**From:** [Nickie Darling](#)  
**To:** [Chace Pedersen](#)  
**Subject:** written comment for Nelson View development  
**Date:** Monday, May 8, 2023 2:21:01 PM

Hello my name is Nickie Backlin (Darling) my family homesteaded here in the 1800s and I currently own the property and live at 5171 Nelson Siding Road in Cle Elum, WA that will be surrounded with the new Nelson View Development. My family and I have several concerns. The first and foremost is that my great uncle Christopher Fredrick Darling stated several stipulations in his will to keep from a development happening here on the property his grandparents homesteaded on and he and my grandpa both were born, worked, and died on. I would like his will to be read and followed that is filed through Kittitas County. In his will it was stated each parcel that is ever made on this property must have a 1/2 acre or percentage to be a wetland. When I built my home we followed this and every other landowner should as well. Another stipulation was that there was a green zoneset in place to keep houses from being built here back to back and more than just the per 5 acre law the county requires, so that also needs to be followed.

NELSON VIEW
SUBDIVISION

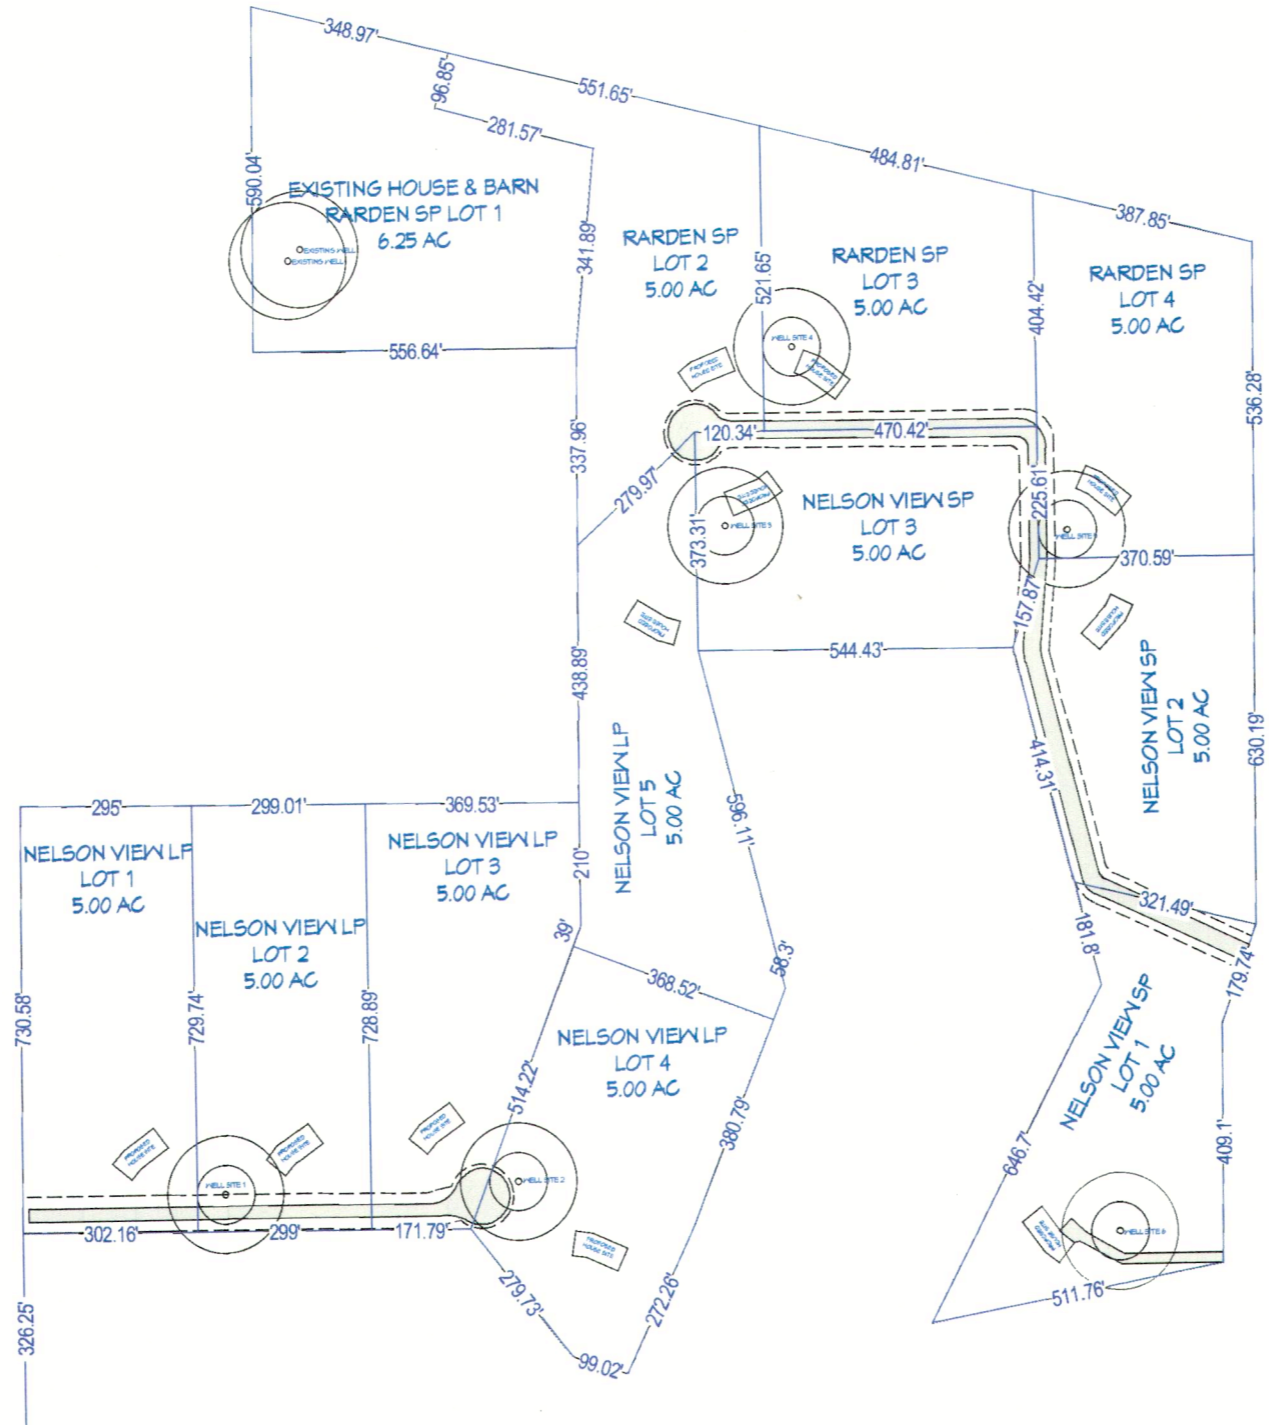
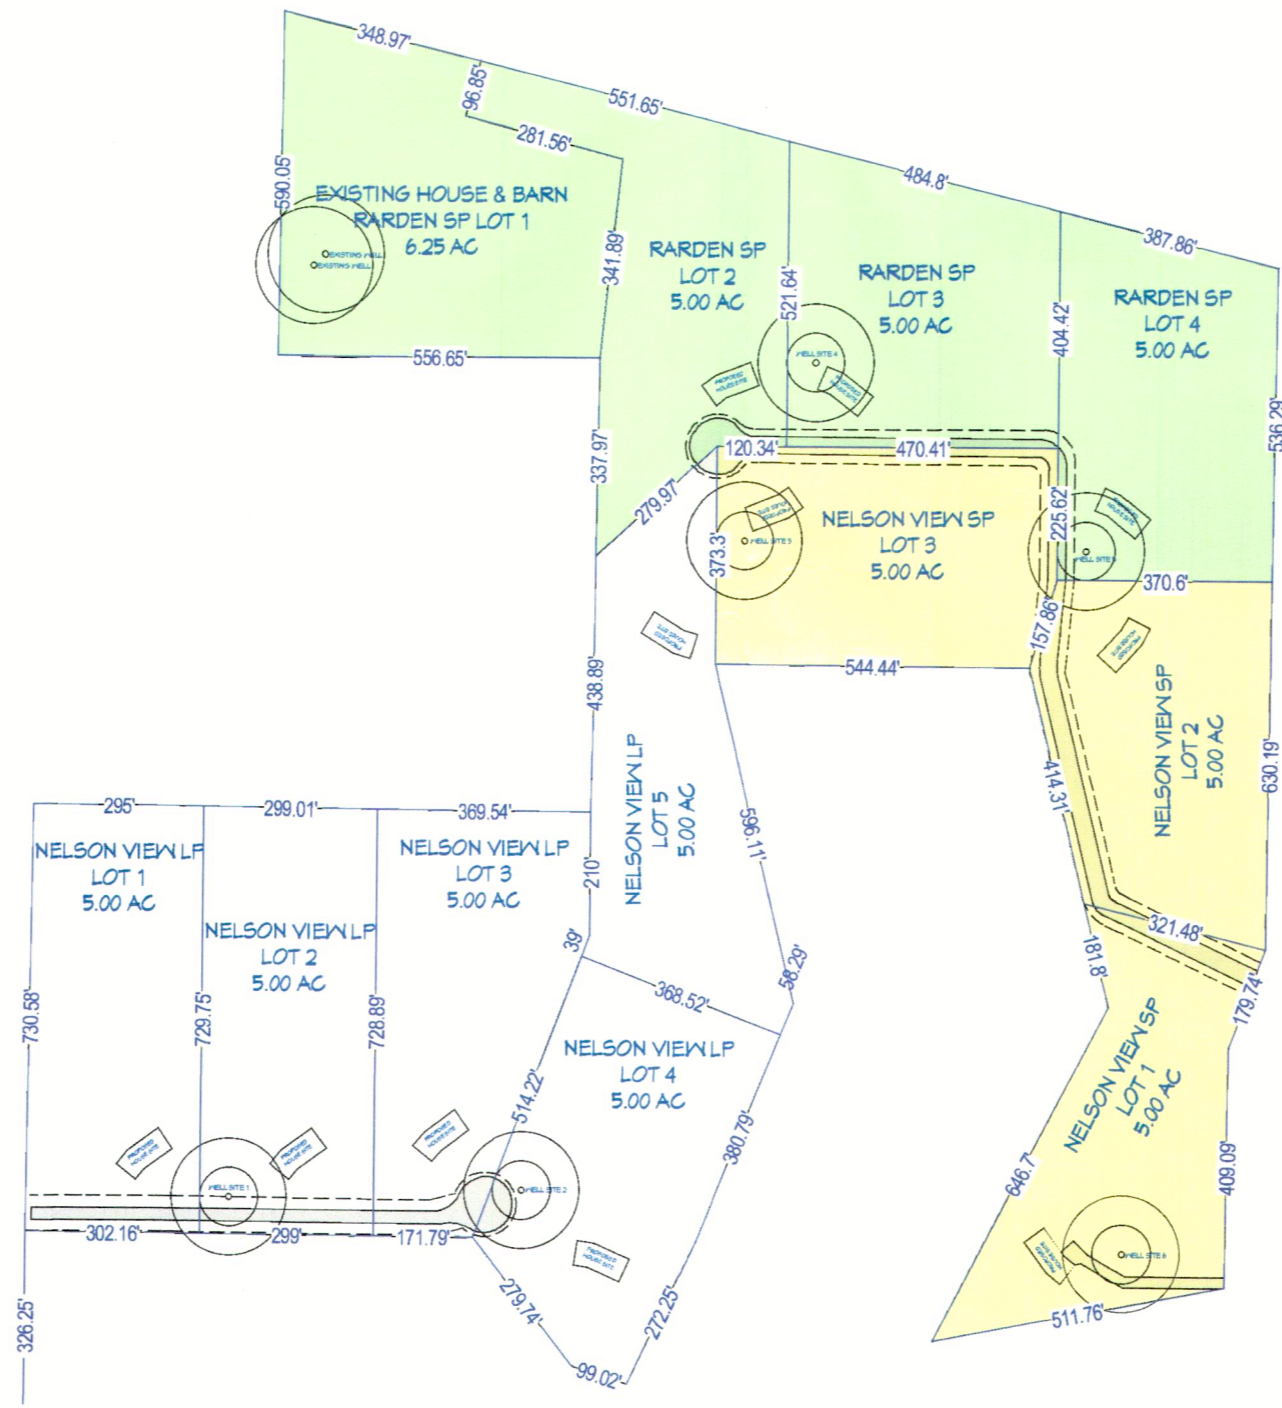
property and they plan to put a shared well in close proximity to this well and this is just morally wrong, we wish to have a large setback and keep the grave in peace. It should be noted this grave has been marked and is protected by the state, I did it myself last year. The new owners also plan to put a roundabout on the same parcel as the grave also in close proximity and we wish to have that put someplace else on another parcel to not disrupt the ground and surrounding ground to the grave of Minni.
